Internal Ref: EXTERNAL/2024/0020

Inner West Council Response: SSD-76927247 – The Timberyards by RTL Co.

Property: Lots bound by Victoria Road, Sydenham Road, Farr Street and Mitchell Street, Marrickville NSW 2204

2 Solar Analysis

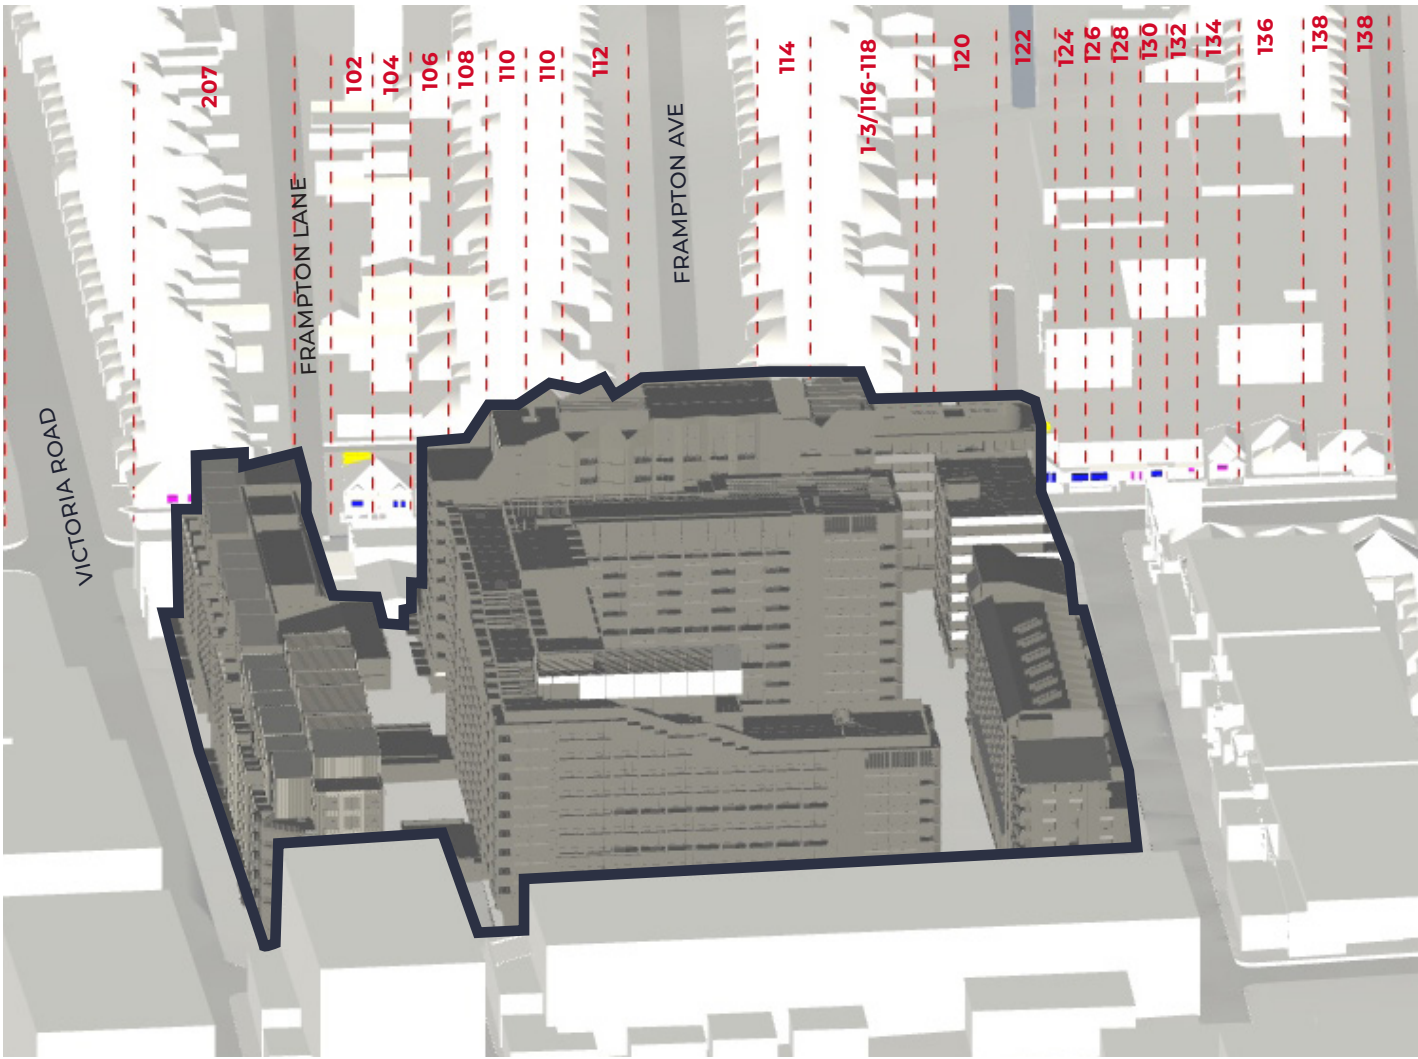
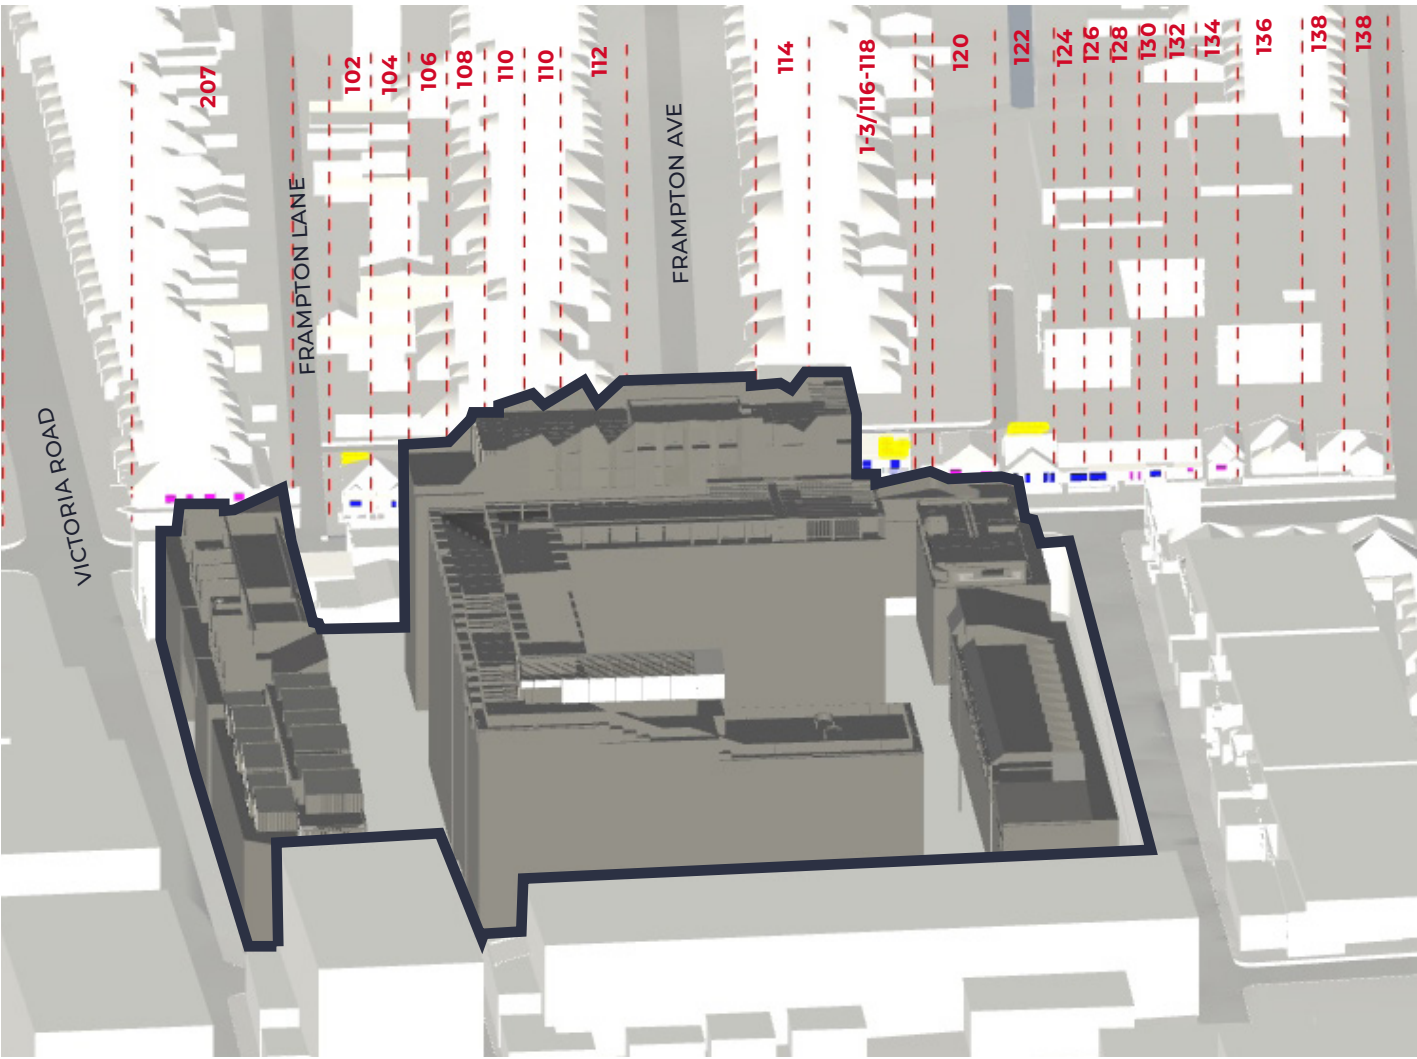
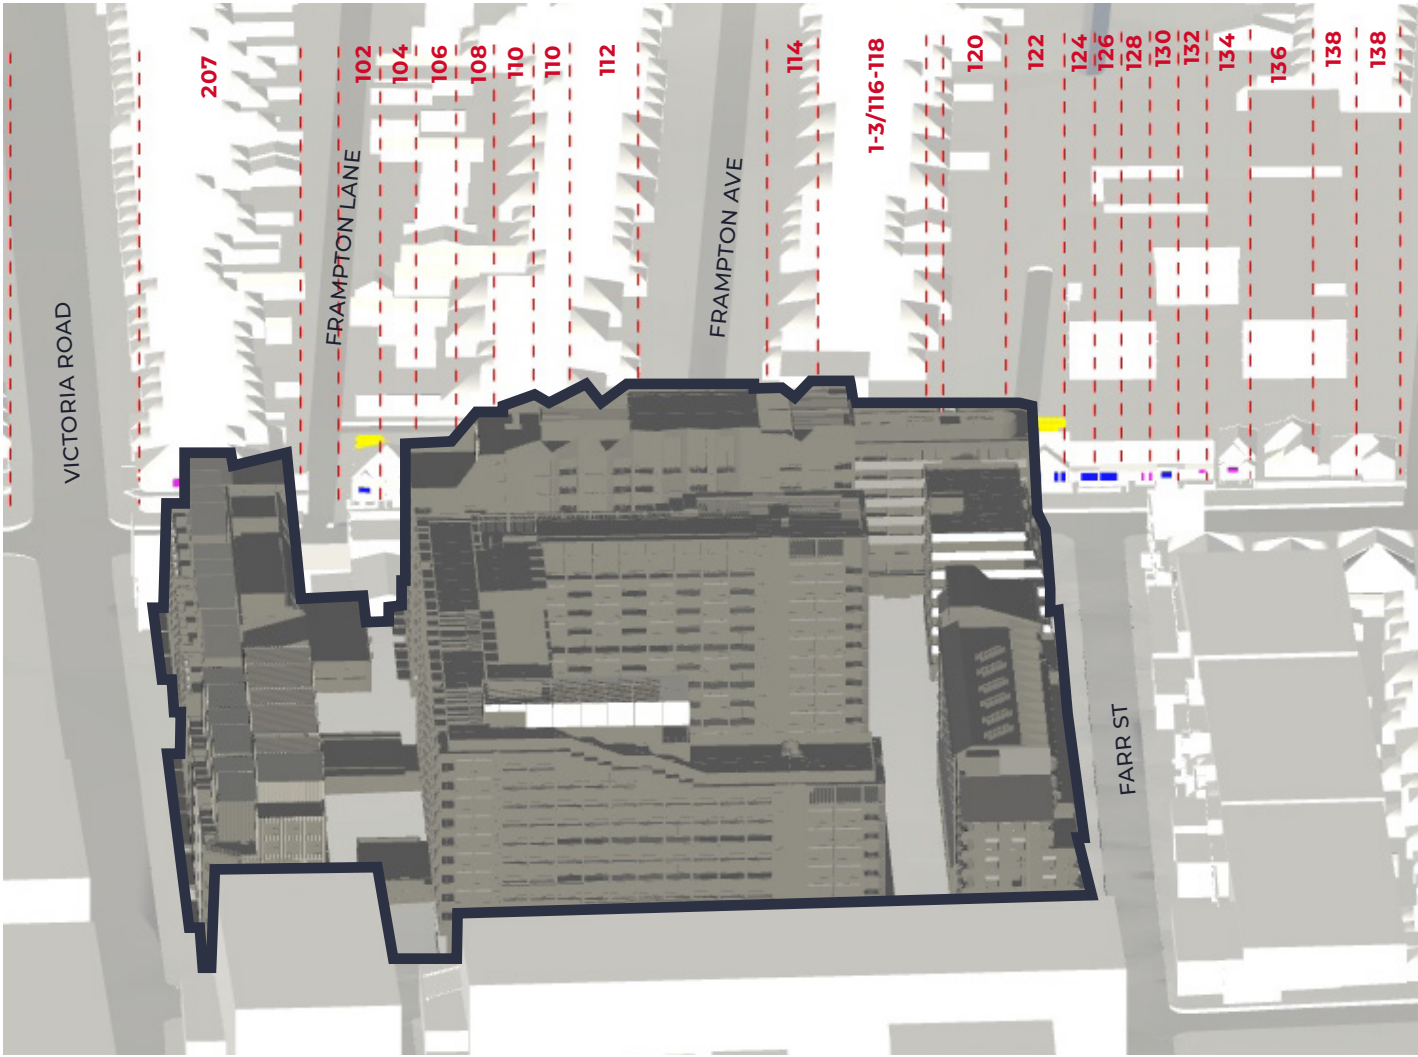
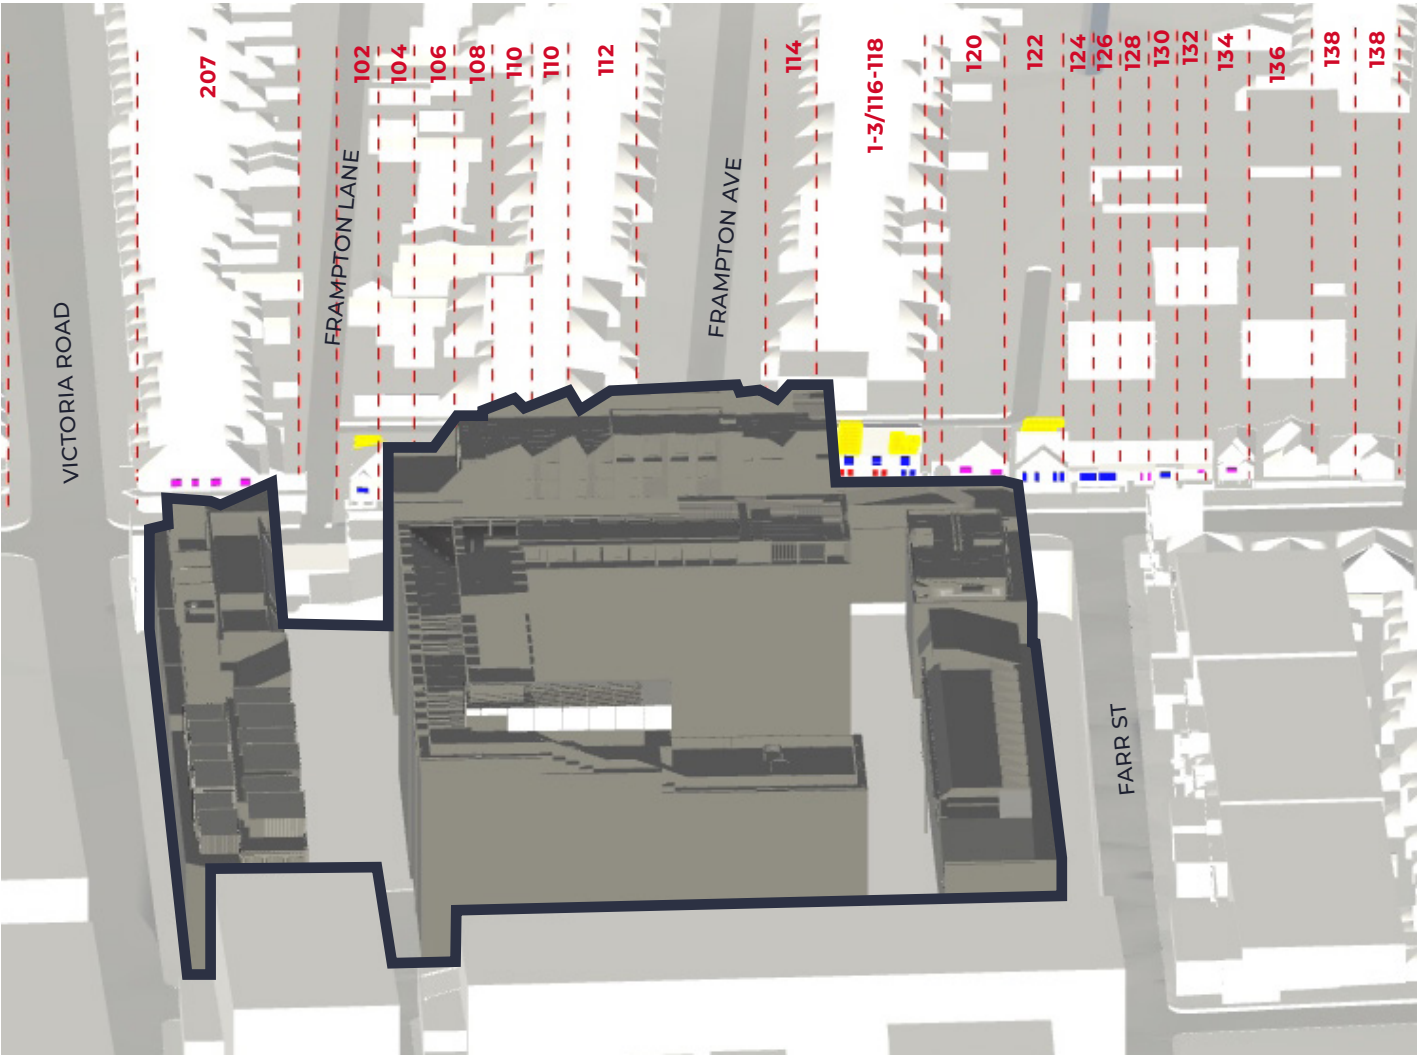
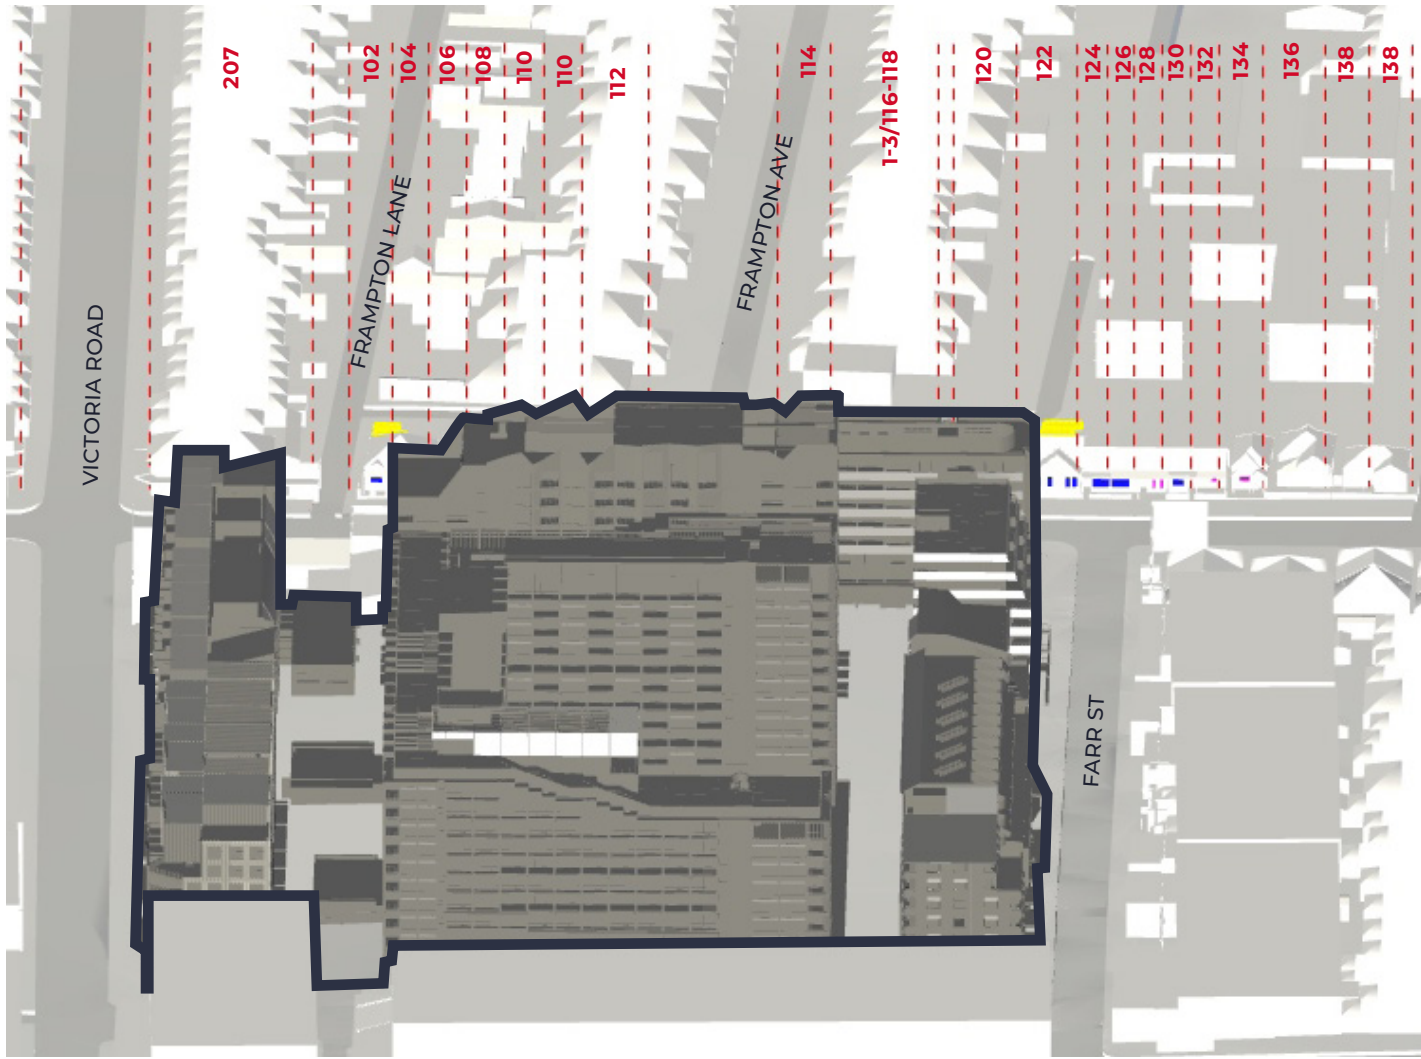
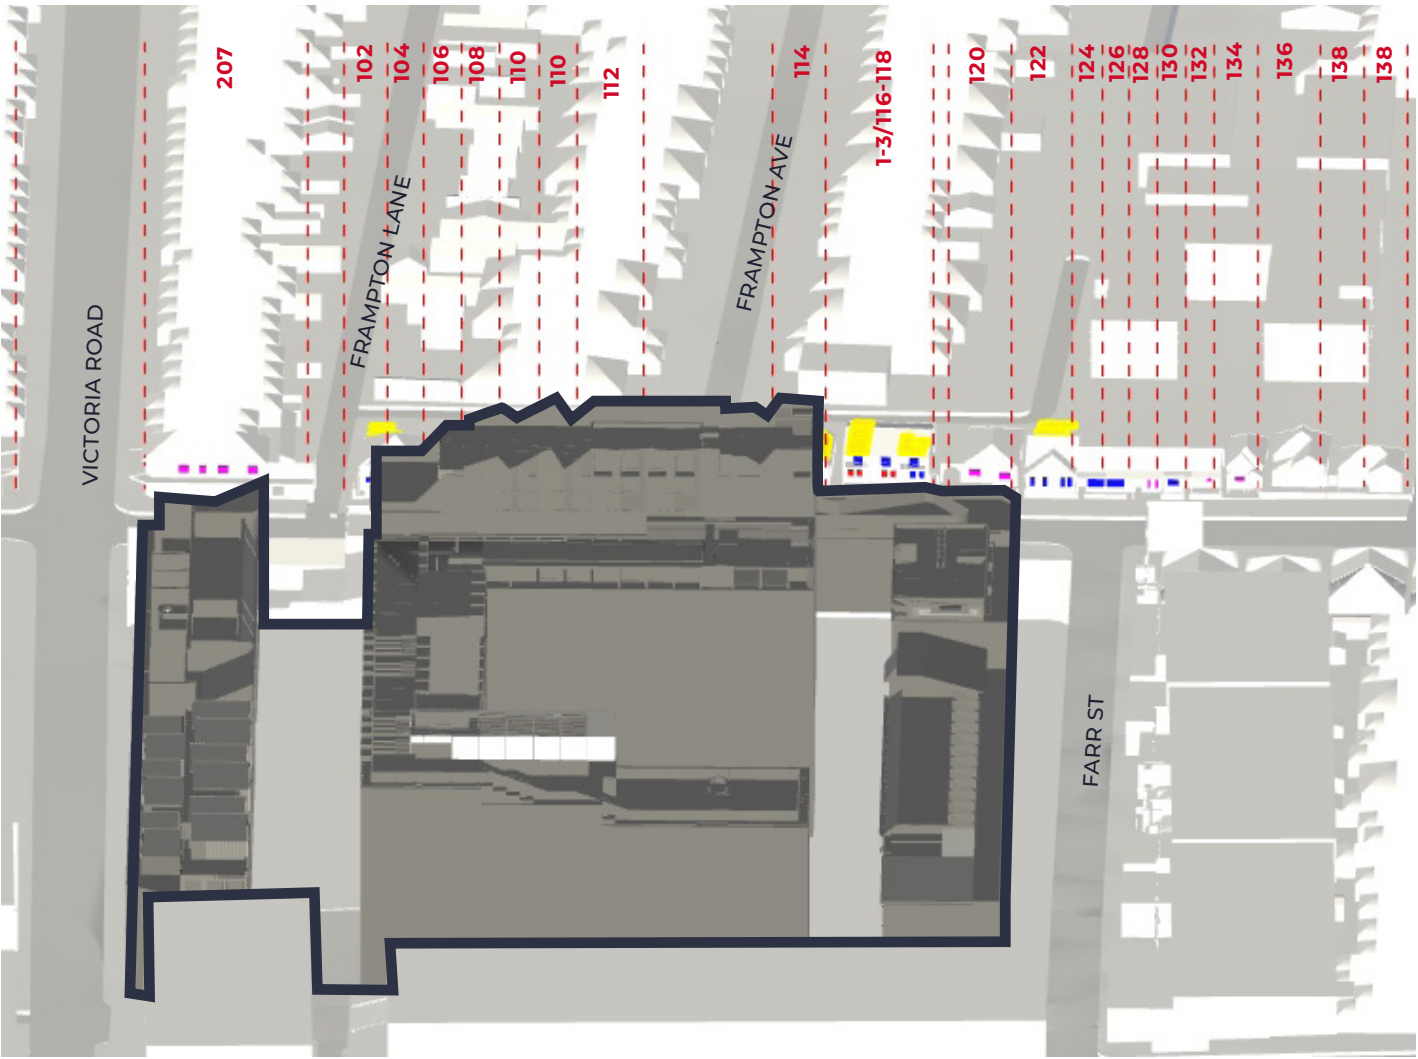
- c) The supplied sun eye diagrams (DA-795-101) and solar access diagrams are of a low-quality and faded and are not sufficient to conduct a comprehensive solar impact assessment most notably to the Corner Site. They should highlight which units are being counted as receiving the required 2 hours.
